**Recommendation Report for Listed Building Consent for Alterations, Extension or Demolition of a
Listed Building**

REF NO: WA/37/19/L

LOCATION: Holly Tree Cottage
The Street
Walberton
BN18 0PH

PROPOSAL: Listed building consent for proposed first floor rear extension (Resubmission of WA/102/18/L).

CLIENT	Mr & Mrs J Waights	SCALE	1:100 @ A3
SITE	Holly Tree Cottage, The Street, Walberton	STATUS	PL / LBC
PROJECT	Proposed First Floor Extension	AUTHOR	AH
DRAWING	002 Proposed Garage & Roof Plans	DATE	23 04 19

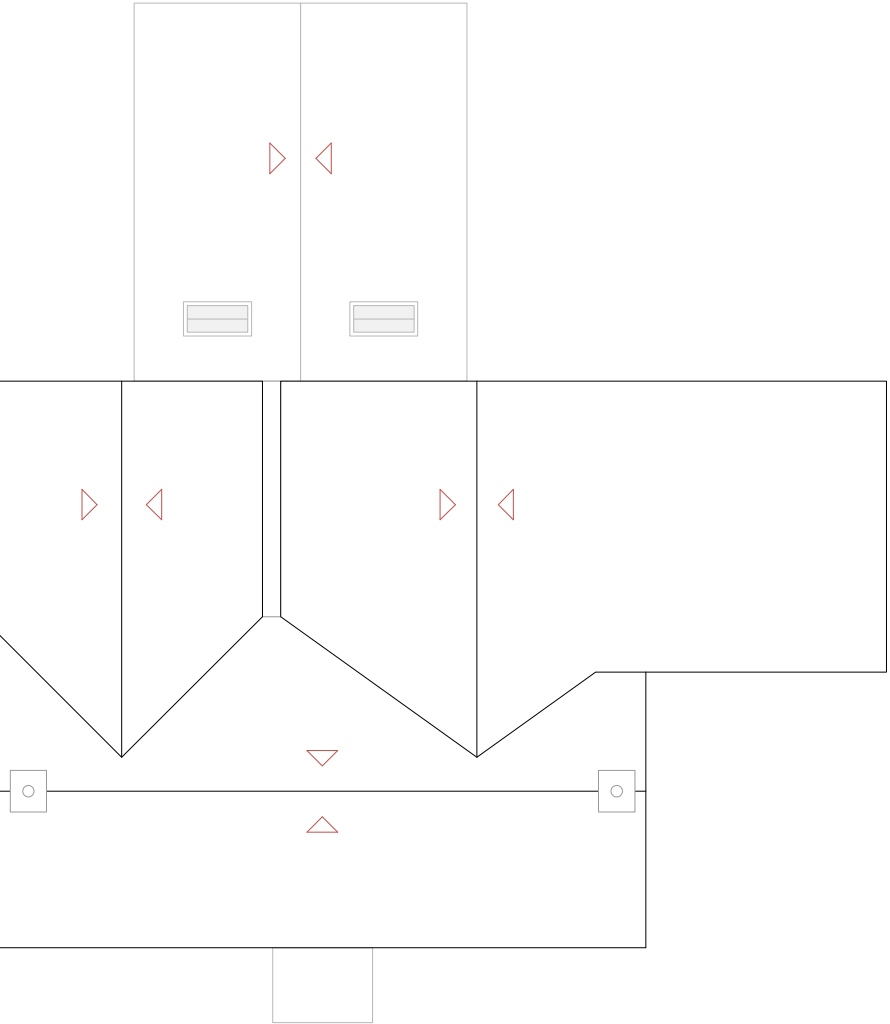
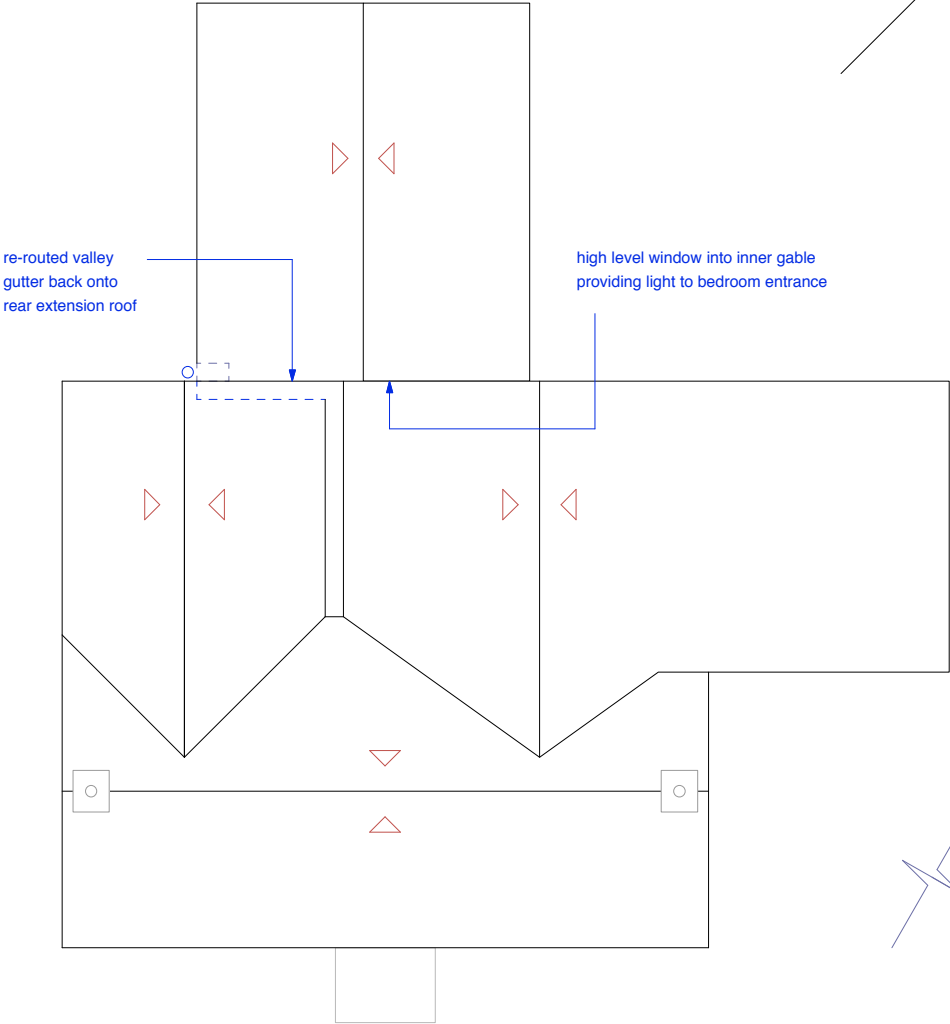
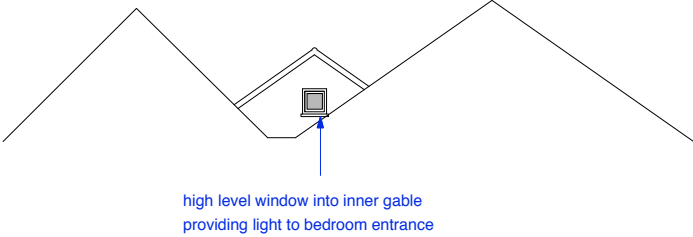
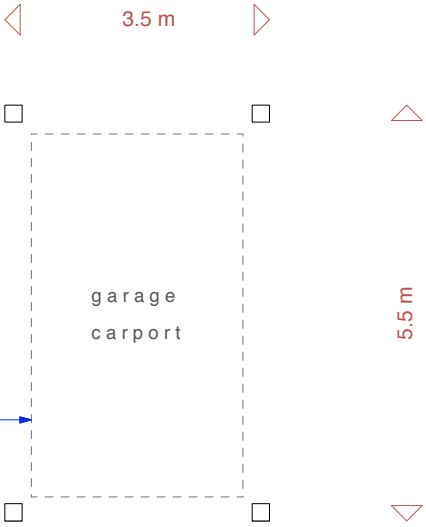
- In its current form would harm the Listed building and Conservation Area.
- Car port would detract from the setting.
- Conflict with policies.

The proposal would result in the loss of one of the existing staircases which is linked to when the house was two properties. This would result in loss of historic fabric and could harm the significance of the cottage. The garage would be dominant and highly visible.

Comments noted. The carport has been removed from the application.

Following these comments, the garage was removed from the application and the staircase is to be retained.

CLIENT	Mr & Mrs J Waights	SCALE	1:100 @ A3
SITE	Holly Tree Cottage, The Street, Walberton	STATUS	PL / LBC
PROJECT	Proposed First Floor Extension	AUTHOR	AH
DRAWING	003 Existing Elevations	DATE	23 04 19

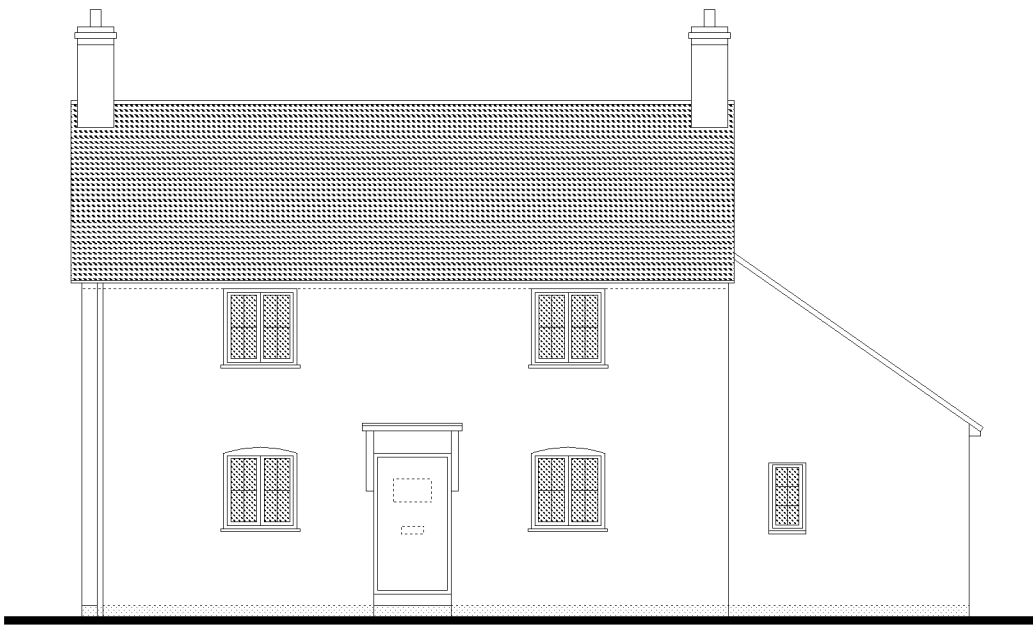
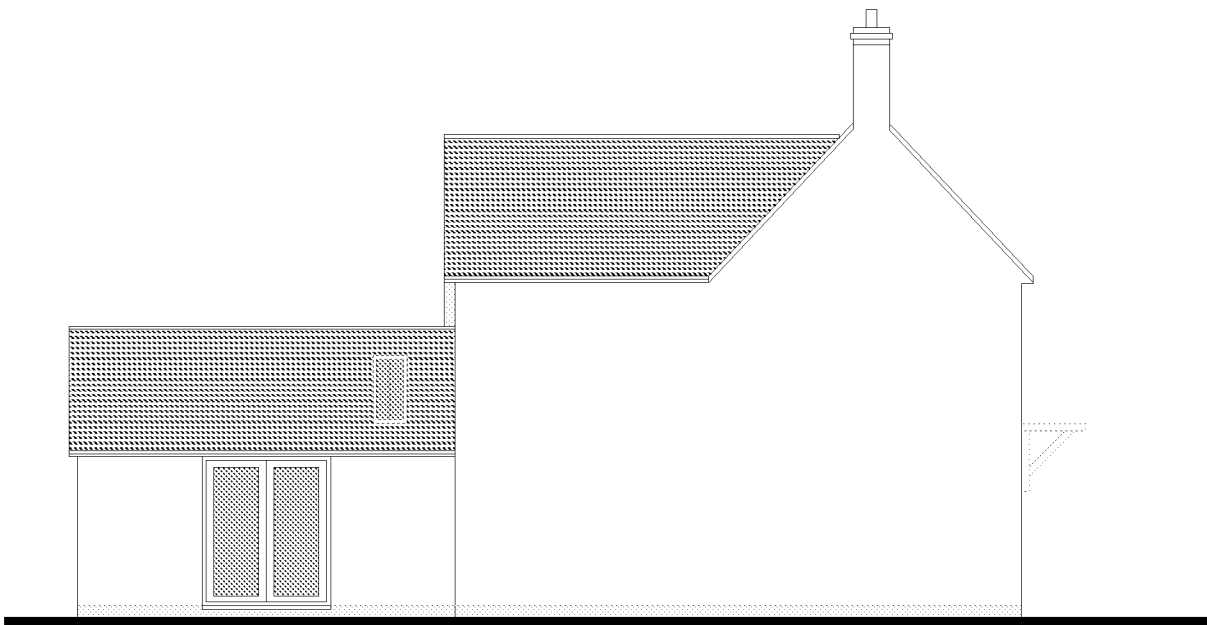
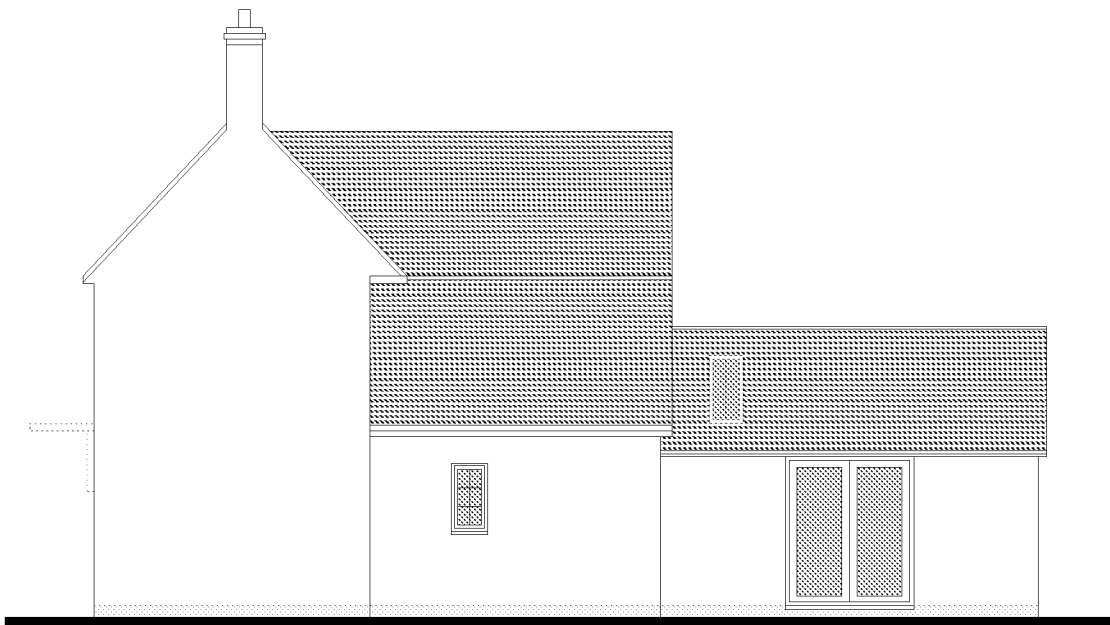
The extension involves a gable end which sits below the existing historic gables and somewhat subservient. The use of a gable end is consistent with the use of other gables at the side and end of the dwelling.

CLIENT	Mr & Mrs J Waights	SCALE	1:100 @ A3
SITE	Holly Tree Cottage, The Street, Walberton	STATUS	PL / LBC
PROJECT	Proposed First Floor Extension	AUTHOR	AH
DRAWING	001 Existing & Proposed Floor Plans	DATE	23 04 19

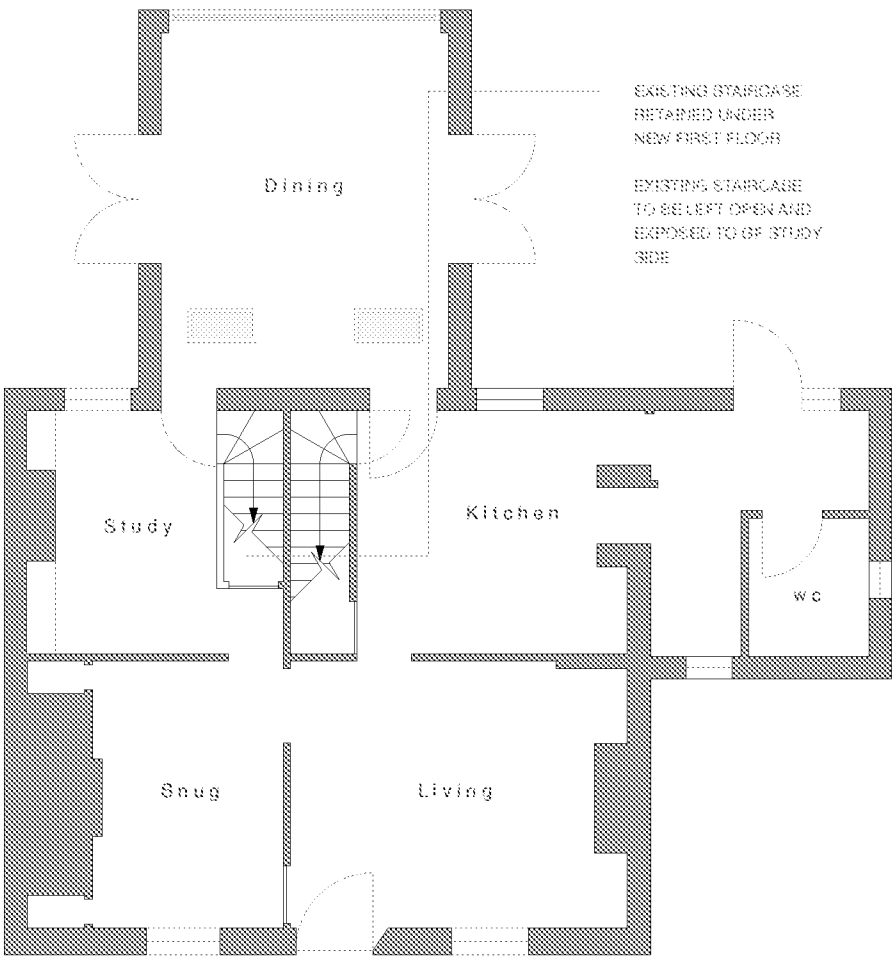
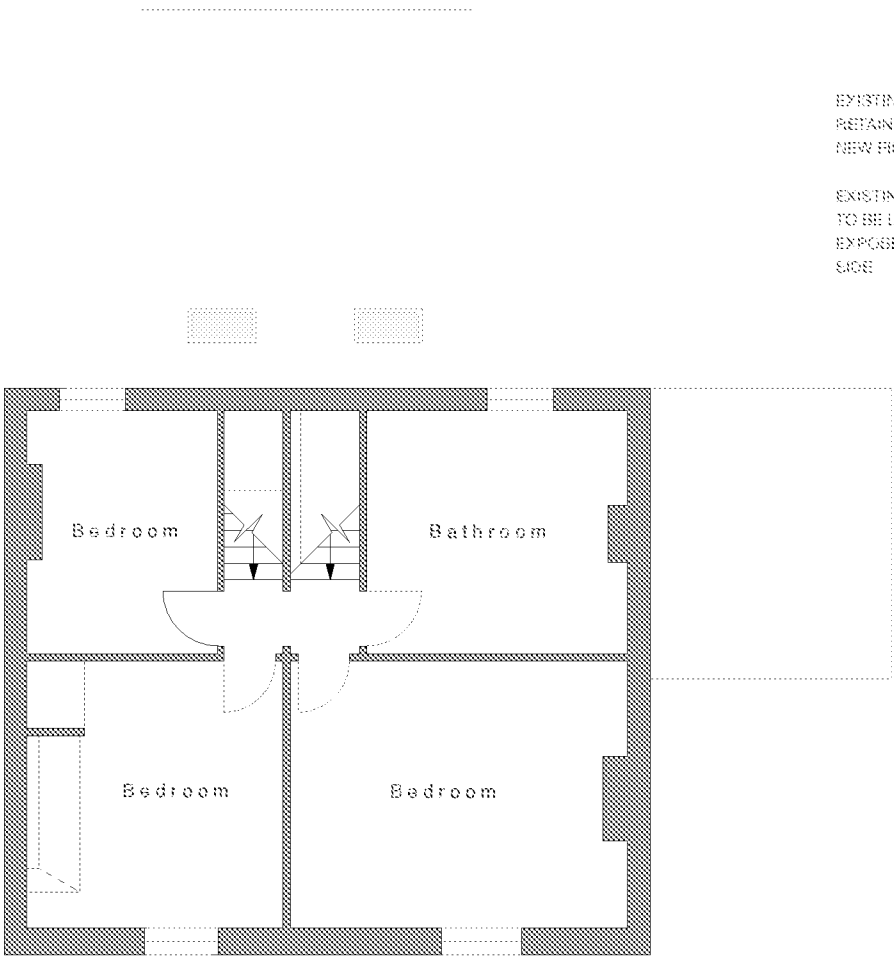
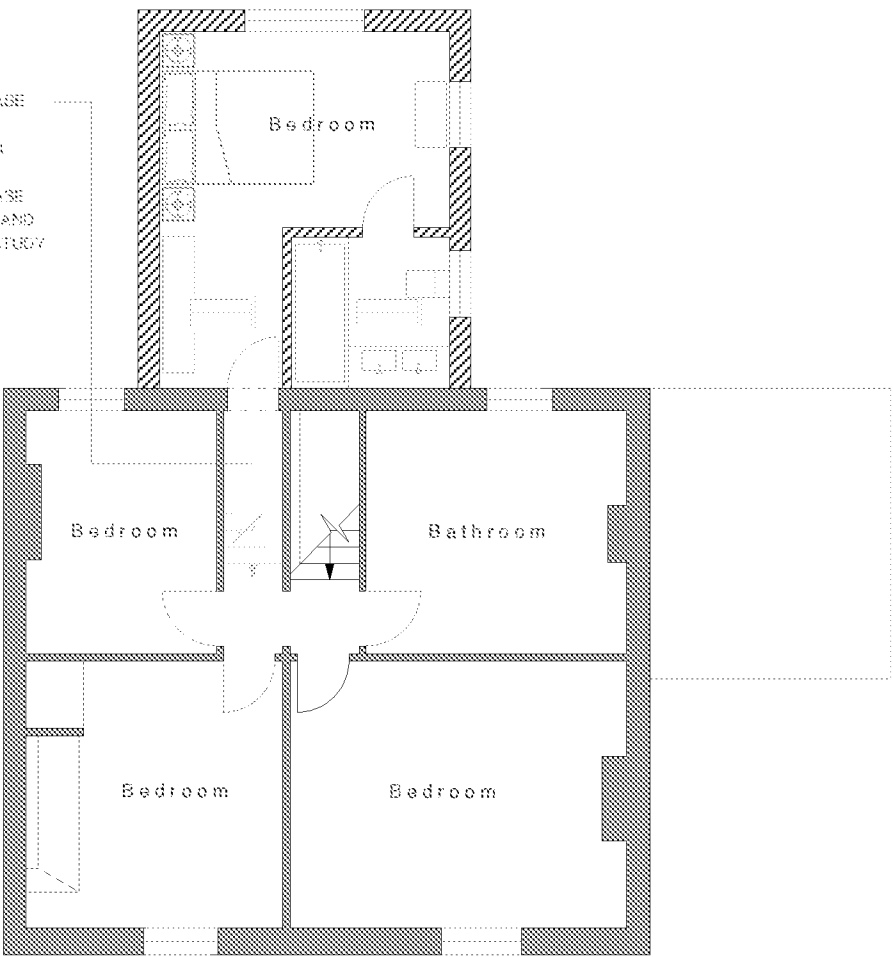
A staircase which was formed when the property was originally 2 dwellings will be retained but flooring will be inserted above to provide level access to the extension. This will ensure the stairs remain for further reference. Details could be submitted to indicate how the flooring will be inserted without harming the historic fabric.

Revised plans show the removal of the carport. This is positive and reduces the harm to the Listed building and Conservation Area. The staircase will be retained with flooring inserted on top, which will ensure the stairs remain. On balance the revised proposal will not harm the significance of the heritage assets or their setting.
